## WEST SUSSEX COUNTY COUNCIL CONSULTATION

| <b>FROM:</b>                    | WSCC - Highways Authority                                                                                                                                                                                                                                                                                                                                                                                                       |
| <b>LOCATION:</b>                | Co-op Stores<br>2 Nyetimber Lane<br>Bognor Regis<br>PO21 3HG                                                                                                                                                                                                                                                                                                                                                                    |
| <b>SUBJECT:</b>                 | AW/359/20/PL<br><br>Introduction of one way system & marked <u>parking</u> bays to the existing parking area, new armco barrier to protect shopfront, new mechanical plant at rear of store with key-klamp protectio

A. TRAFFIC CALMING RESTRICTIONS REMOVED AS REQUESTED BY HIGHWAYS DEPT. 15.03.2021

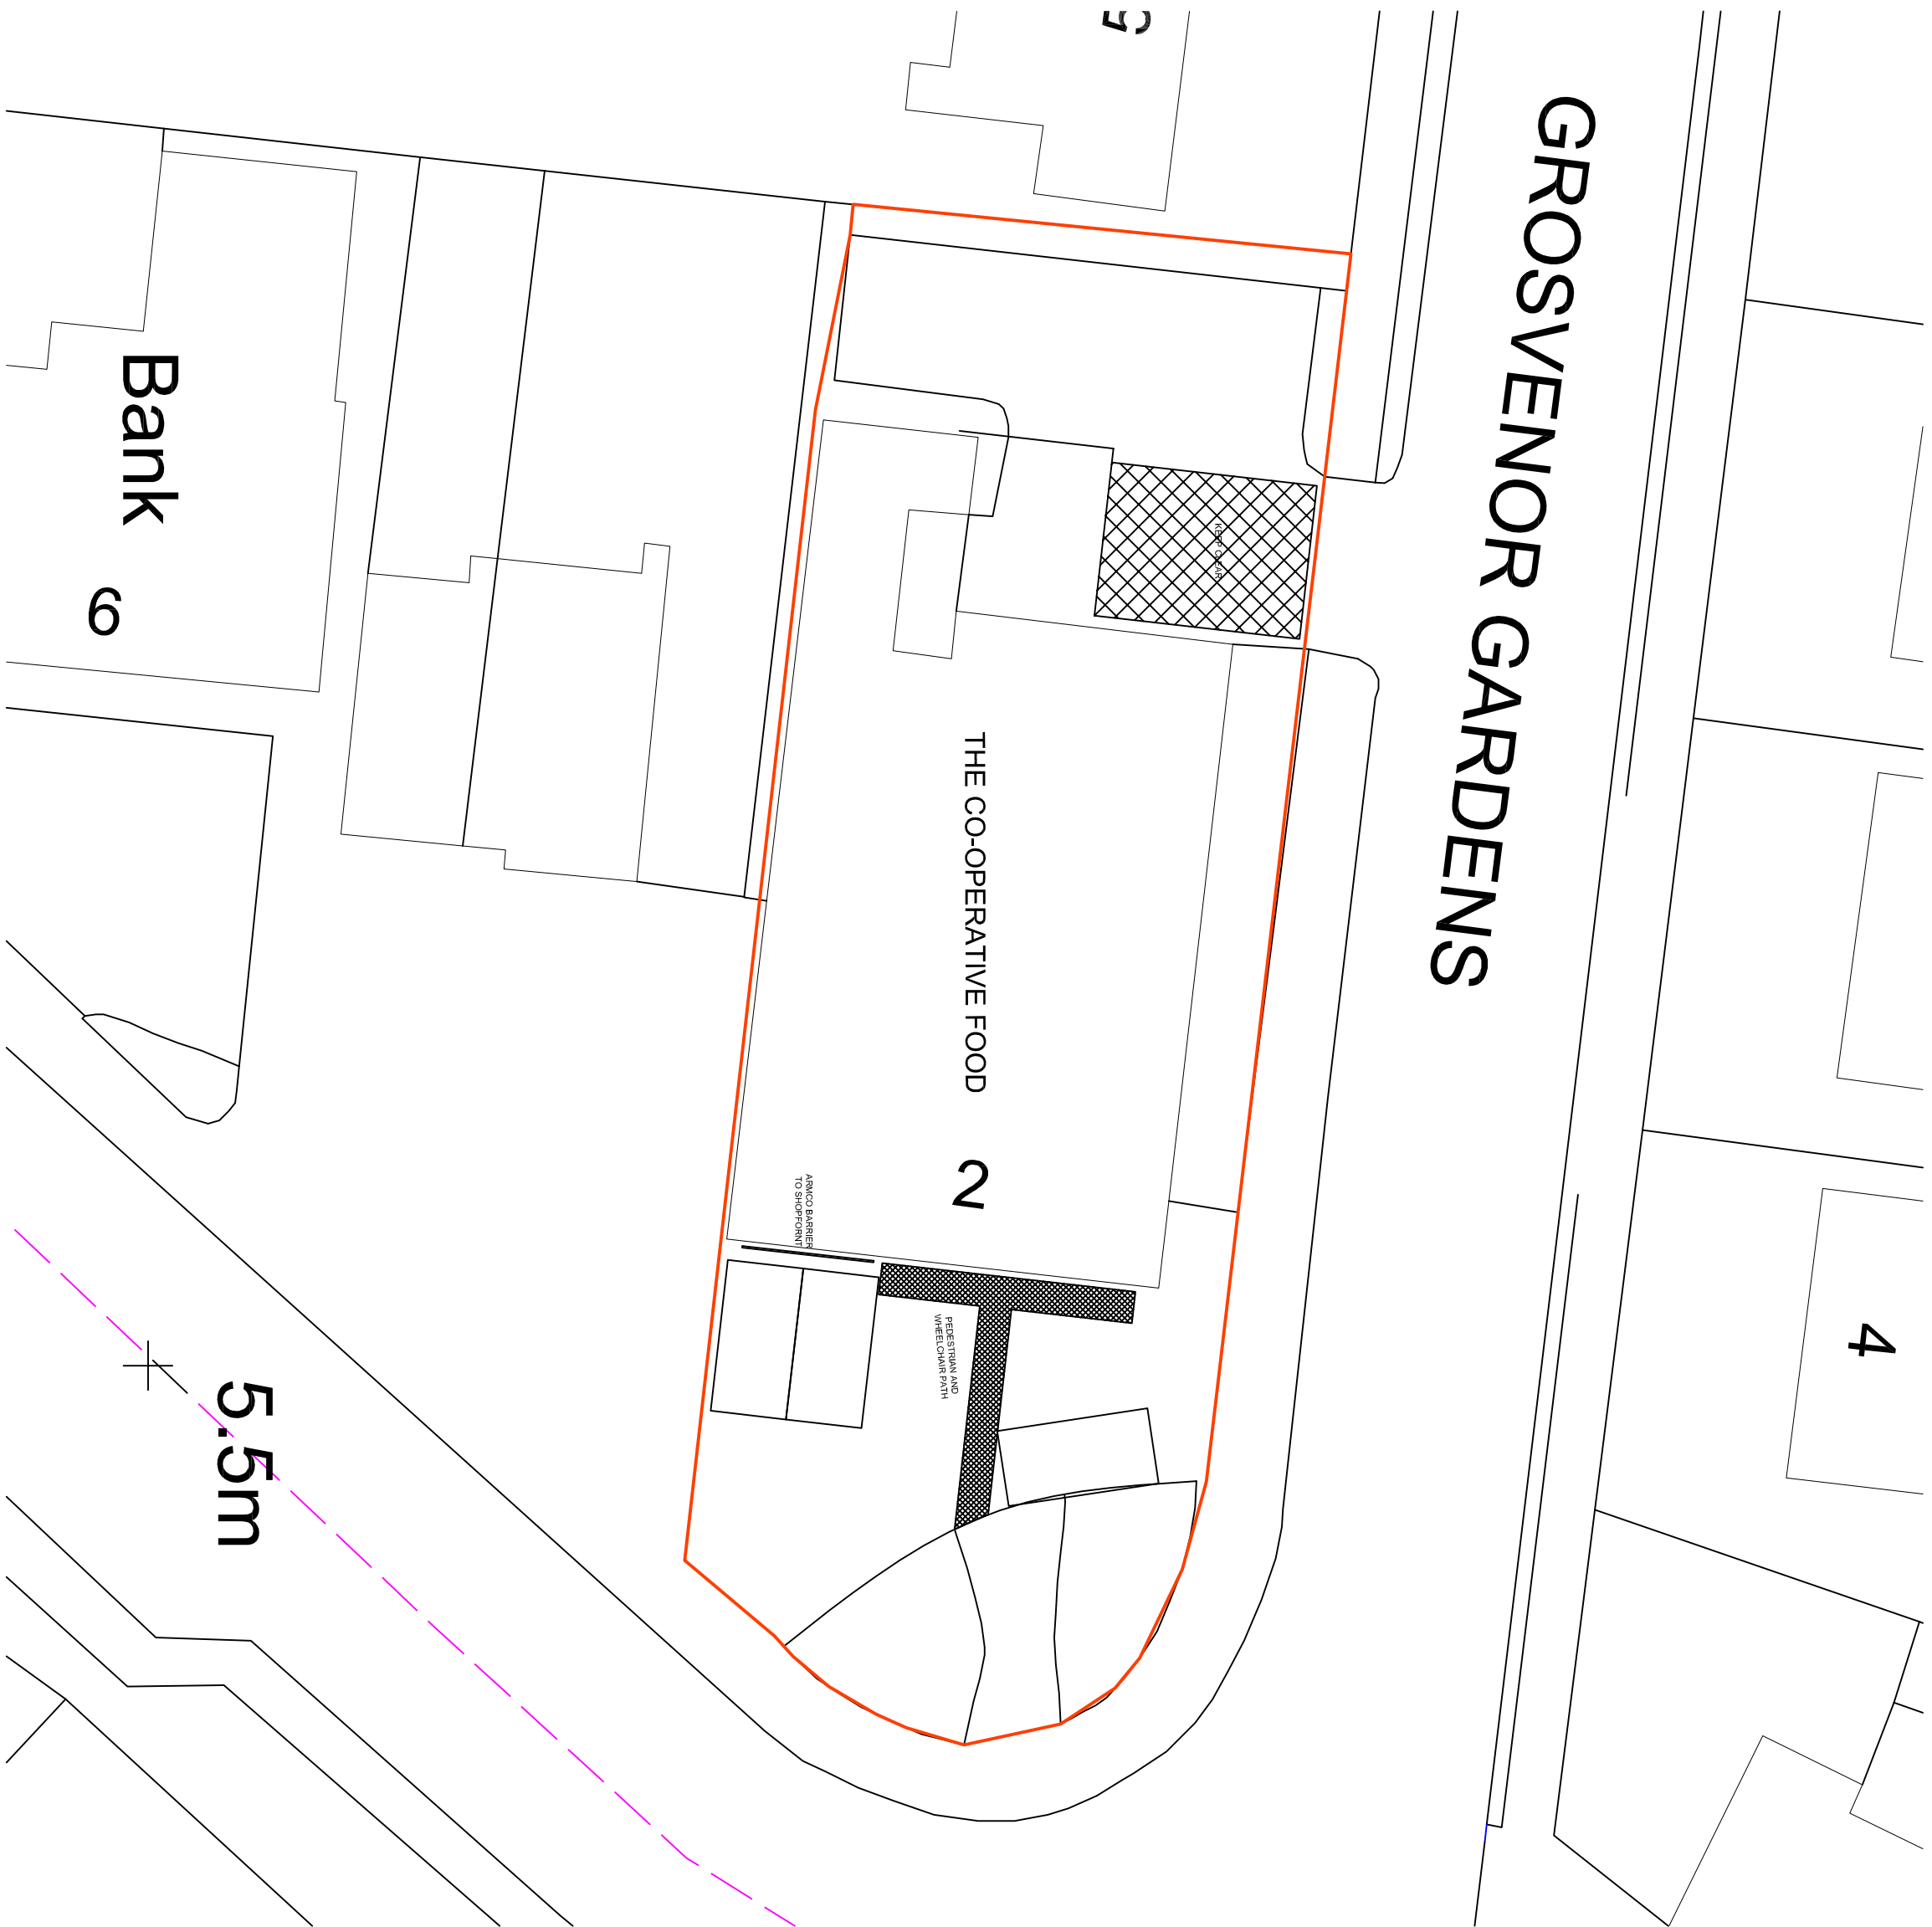
All proposed works appear to be within the sites red line boundary so will take place on private land. Except for the speed bump at the entrance which appears to be slightly on highway land (footway). This will need to be moved in so it's not on highway land.
